**Written Representation  
for the  
Royal Society for the Protection of Birds  
Comments on selected Deadline 1 and Deadline 2 submissions**

**Submitted for Deadline 3  
21 April 2022**

**Application by Hornsea Project Four Limited for an Order  
Granting Development Consent for the Hornsea Project Four Offshore Wind  
Farm**

**Planning Inspectorate Ref: EN010098  
RSPB Registration Identification Ref: 20029909**

**Figure 2 Proposed new structure locations with heatmap analysis**

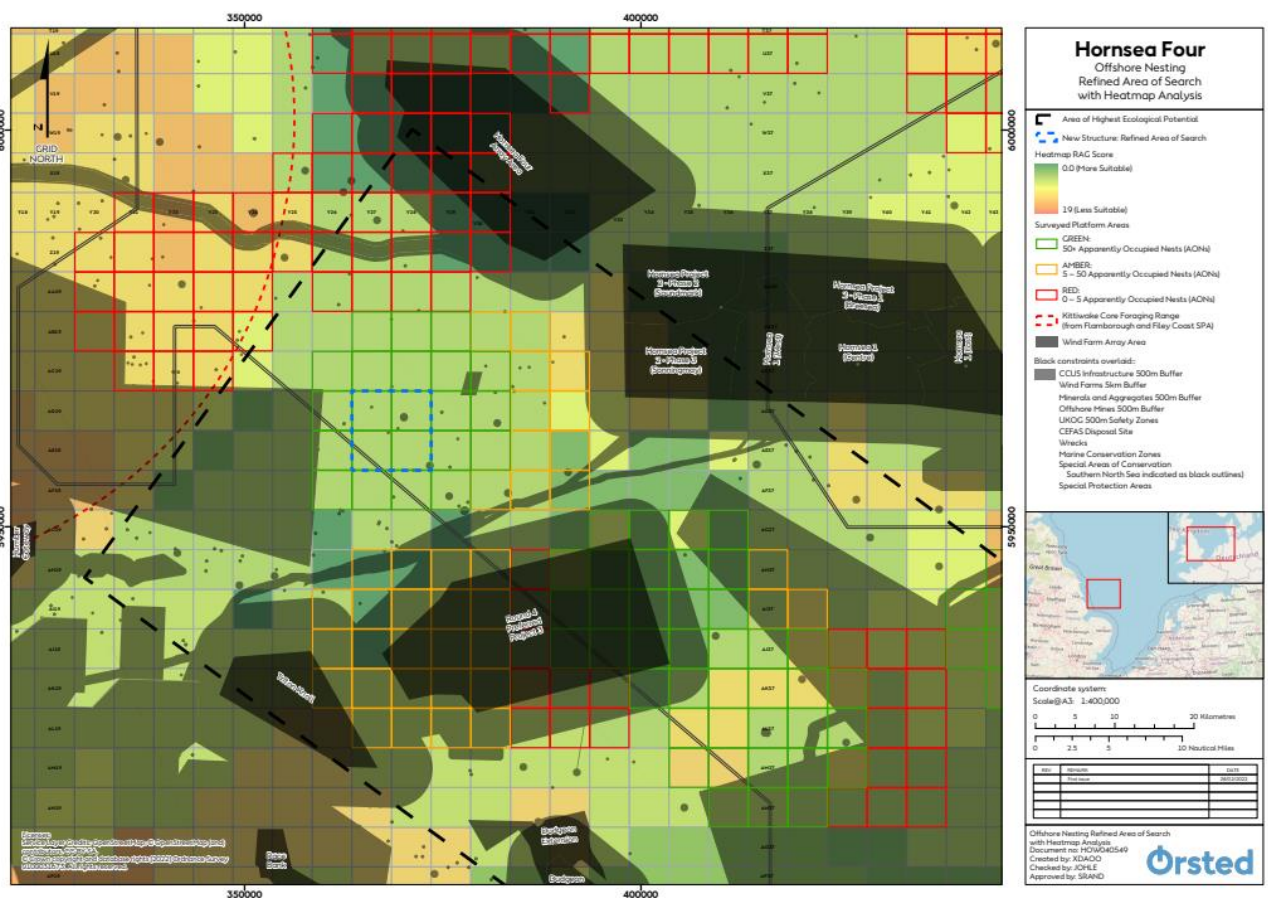
p13, para 8.1.1.1	The RSPB remains concerned that detailed site selection is still ongoing and as such there is still no specific detail on the chosen location or mechanism (new structure or repurposed structure) in front of the examination. Each raises fundamentally different issues in respect of how and whether they can be legally secured.

Section 8, para 8.1.1.9	The RSPB requests clarification on when the results of the geophysical and geotechnical work will be submitted to the examination in respect of precise site selection for a potential new structure.
Section 9.1.2, Adaptive management	<p>At paragraph 9.1.2.2, the Applicant lists examples of possible adaptive management measures that could be used at an offshore artificial nesting structure. We consider it important that the practicality and potential benefit of any suggested adaptive management is explored at a site-specific level as part of the examination process to ensure the Examining Authority and Secretary of State are informed as to their feasibility.</p> <p>At this stage we offer comments on two of the measures listed.</p> <p><u>Provision of supplementary food</u> We have concerns as to how feasible or sustainable this would be, especially on an offshore structure.</p> <p>Supplementary feeding of kittiwakes has been carried out successfully at an artificial site on land (an old air force site) where nests could be accessed with a sliding glass panel and provided 3-4 times a day i.e. very time intensive. This level of feeding improved reproductive success but overall productivity still appeared to be linked to the natural prey resource (Gill et al. 2002).<sup>7</sup> Although no clear carry-over effects to lifetime reproductive success were observed, fed nests were expected to produce more breeding recruits because of their higher productivity (Vincenzi et al. 2015).<sup>8</sup></p> <p><u>Use of kittiwake calls and decoys</u> Decoys have been used at a number of sites but it is not clear whether sites would have been colonised without the presence of the decoy or not. Clay decoys and disused nests were used at the Gateshead Kittiwake</p>
